Your reference: Modification 5 (05\_0037)  
Our reference: DOC16/129111; EF13/3732  
Contact: Emma Paull (02) 4908 6828  
Electronic correspondence to: [hunter.region@epa.nsw.gov.au](mailto:hunter.region@epa.nsw.gov.au)

**Request for Recommended Conditions of Consent  
Cleanaway Waste Oil Processing Facility (formerly Transpacific) 05\_0037 MOD 5**

I refer to your email to the Environment Protection Authority (EPA), dated 11 February 2016, seeking the EPA's comments and any recommended conditions for the above mentioned modification proposal. The proposal is detailed in the report 'Transpacific Refiners Diversification Project 05\_0037 MOD 5 s75W Environmental Assessment' (EA), dated 14 January 2016.

Table 16 Predicted 1 Hour Odour Concentrations (99th percentile) at for Scenario1 and Scenario 2 (OU)

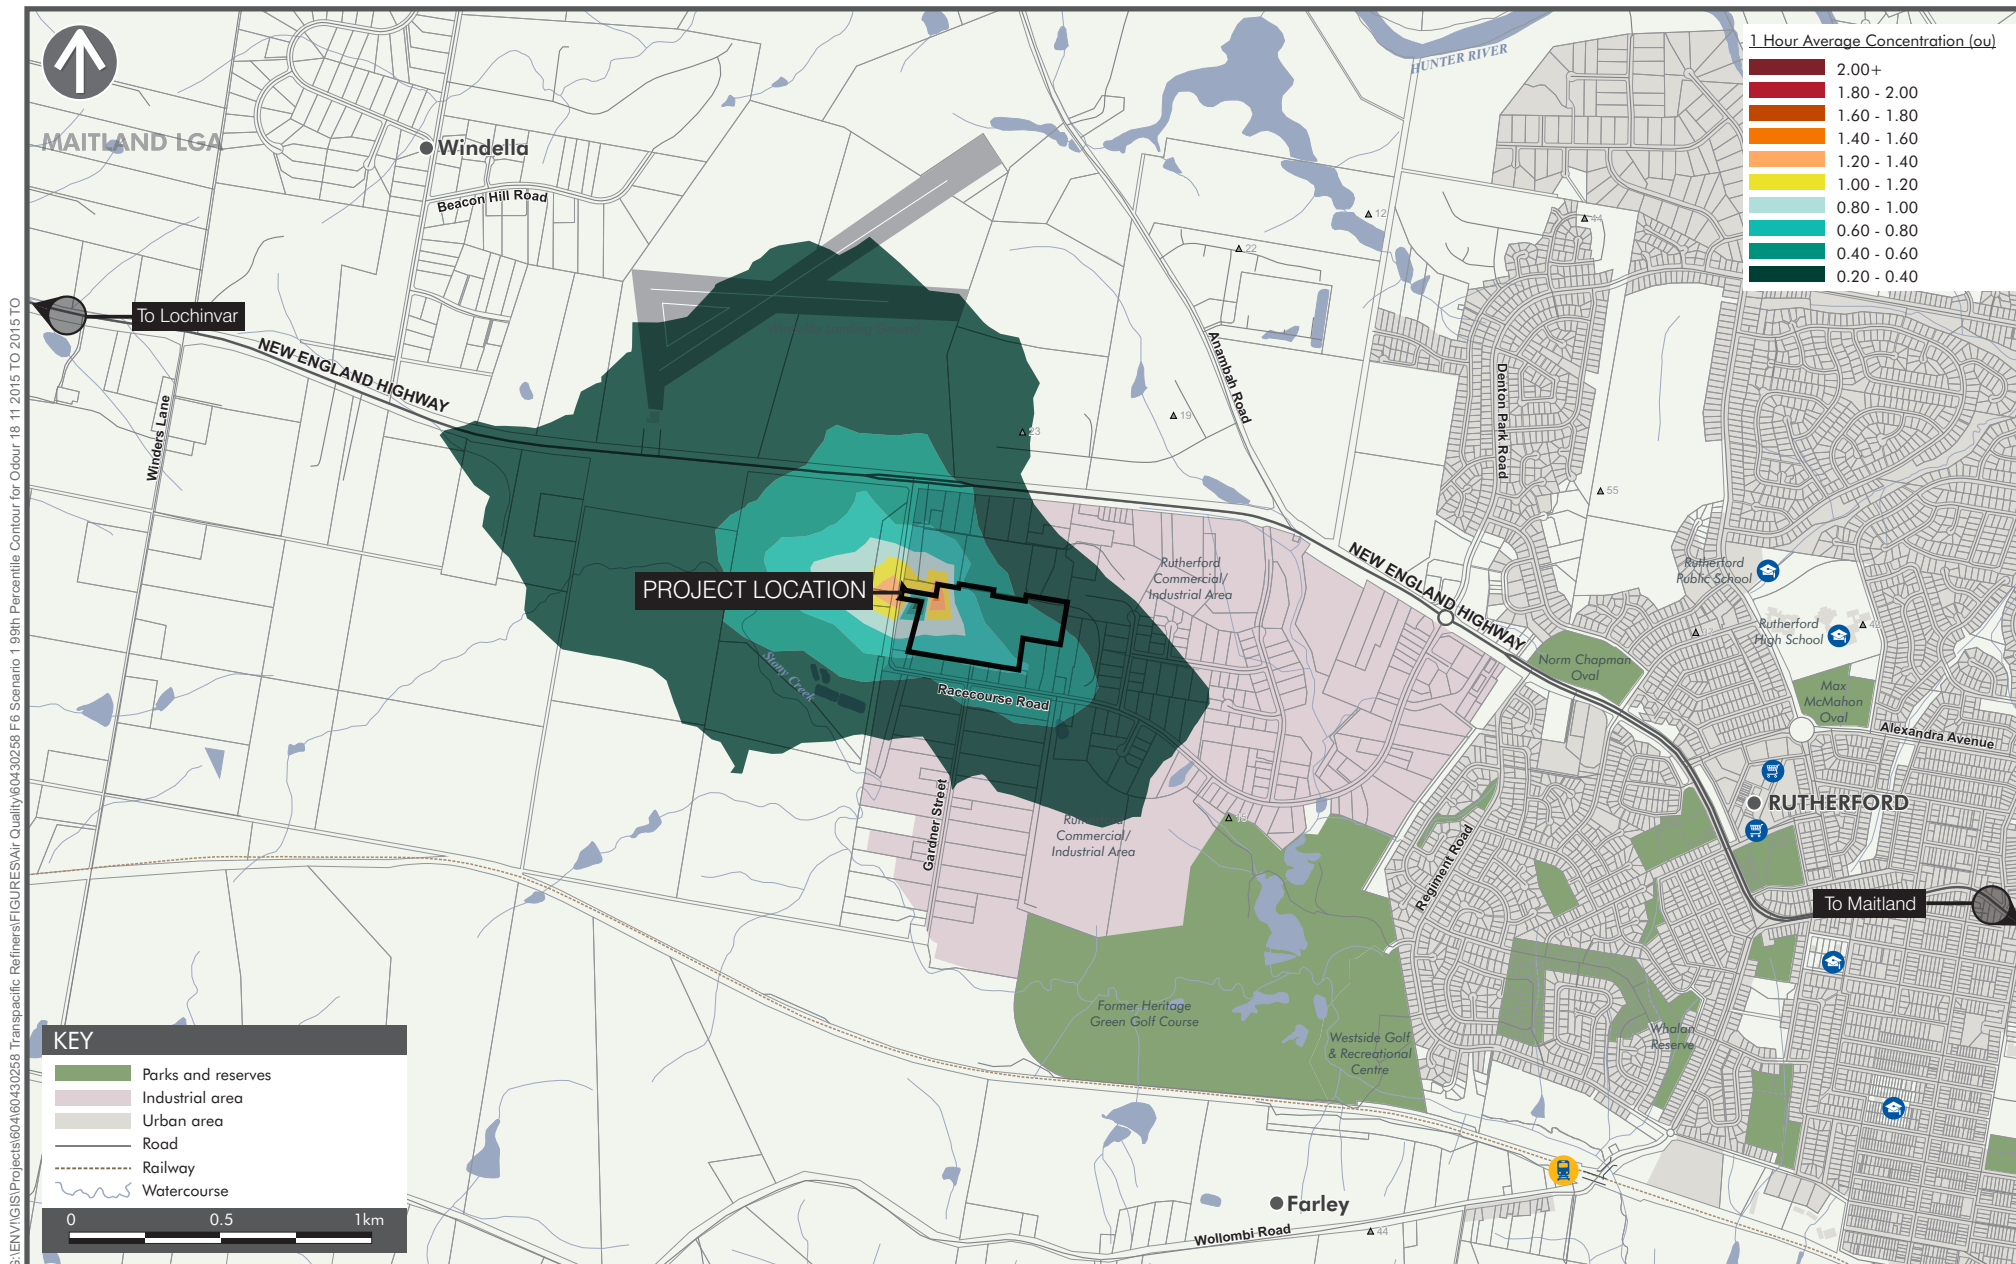
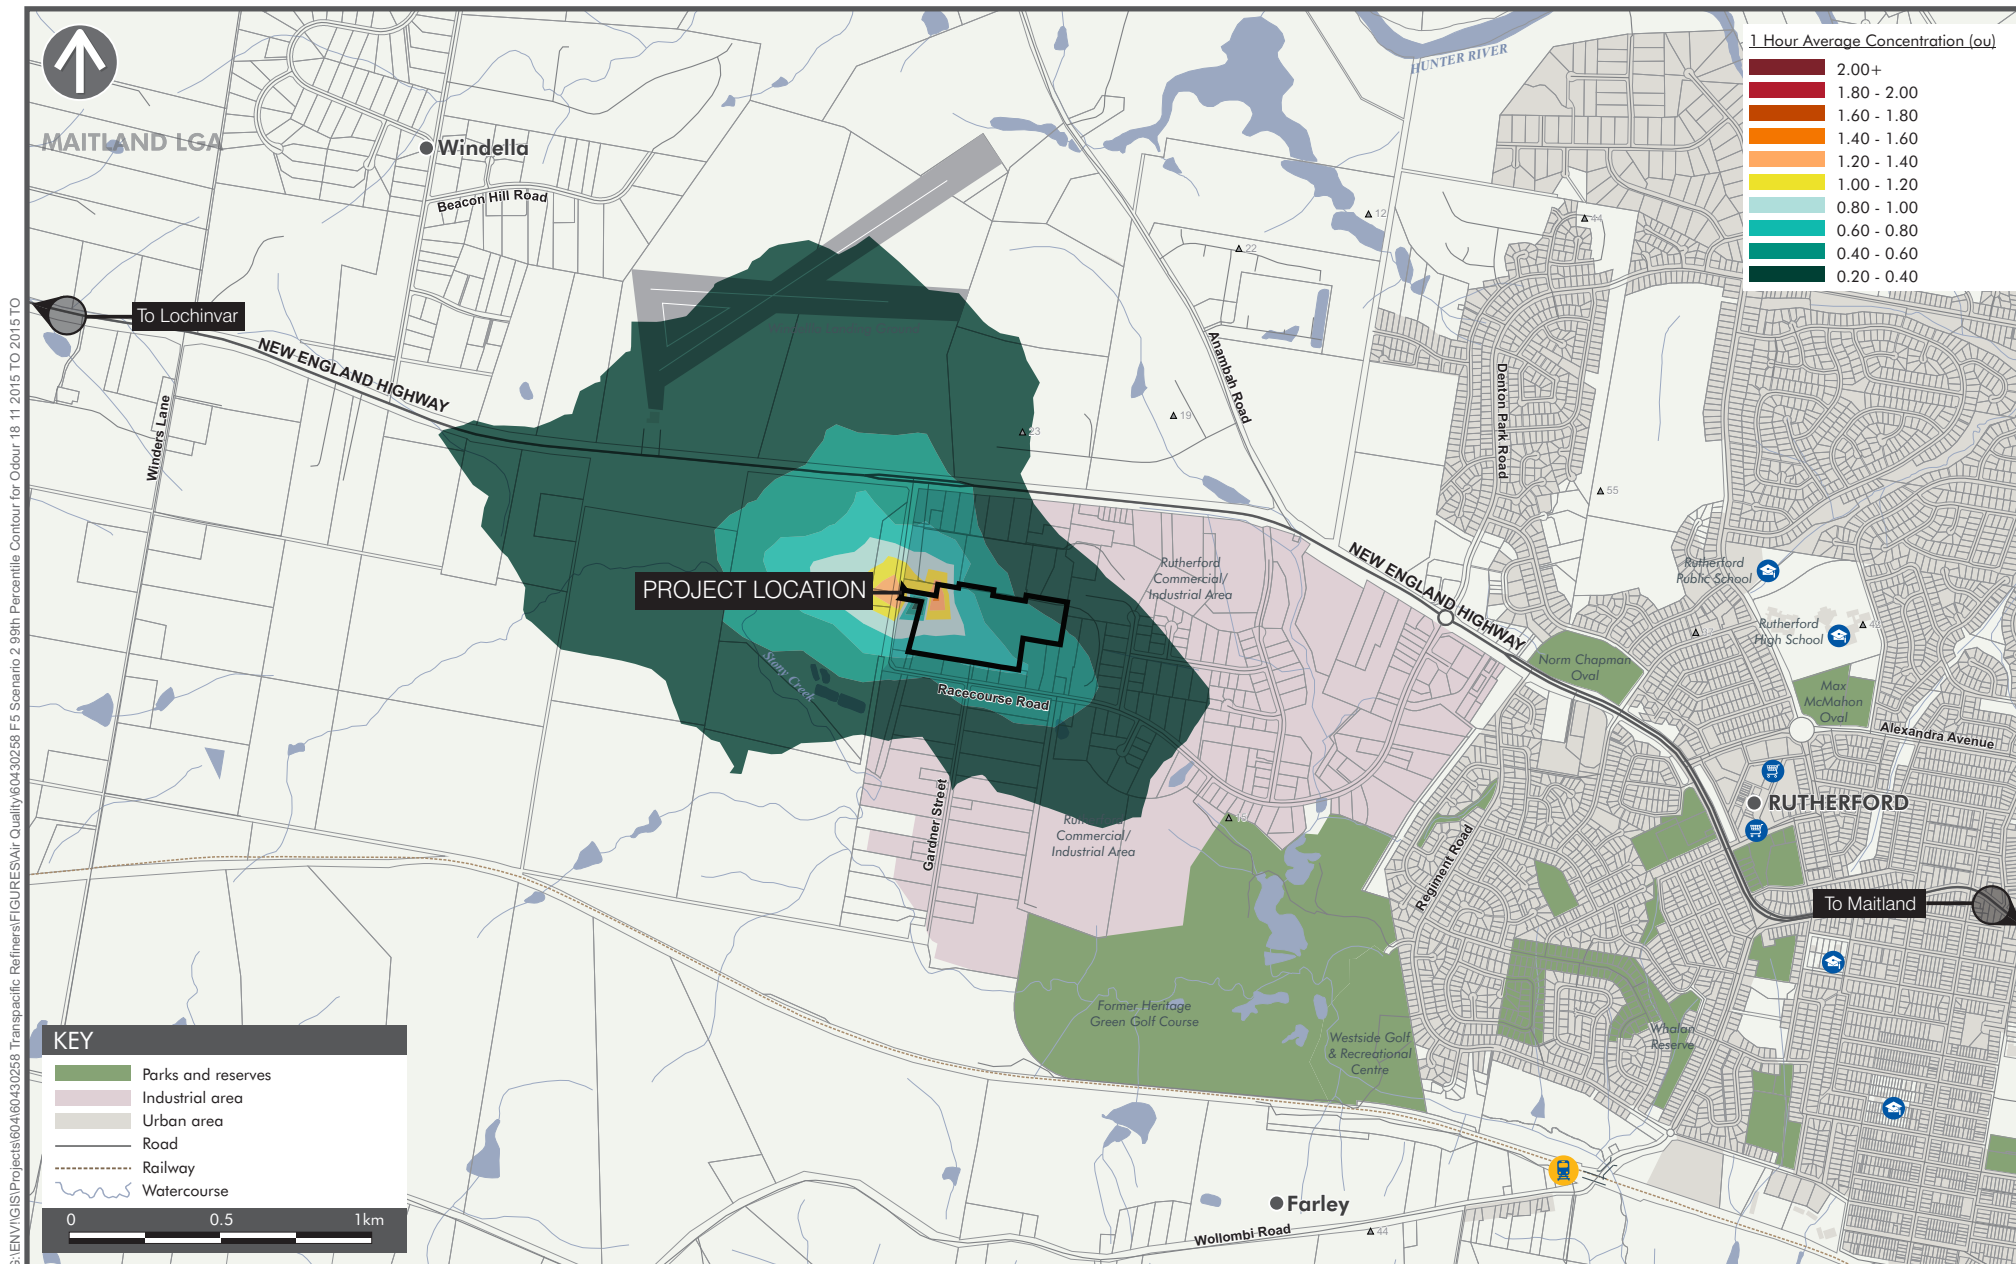
The estimated odour emissions at the most affected sensitive receiver in the AQIA are slightly lower than the estimations in the Katestone Report, however the estimations for the maximum off-site odour emissions are significantly higher in the AQIA. The EPA recommends that the proponent be requested to provide an explanation as to:

- Why the AQIA estimations for maximum off-site odour are significantly higher in the Katestone report and yet result in lower impacts at sensitive receiver sites under a similar modelling scenarios;
- What are the sources of odour that may be contributing to this increase?
- What actions have been and/or are proposed to minimise odour emissions at the plant (the proponent should demonstrate that all reasonable and feasible mitigation measures have been considered to prevent any increase in odour emissions as a result of this project).
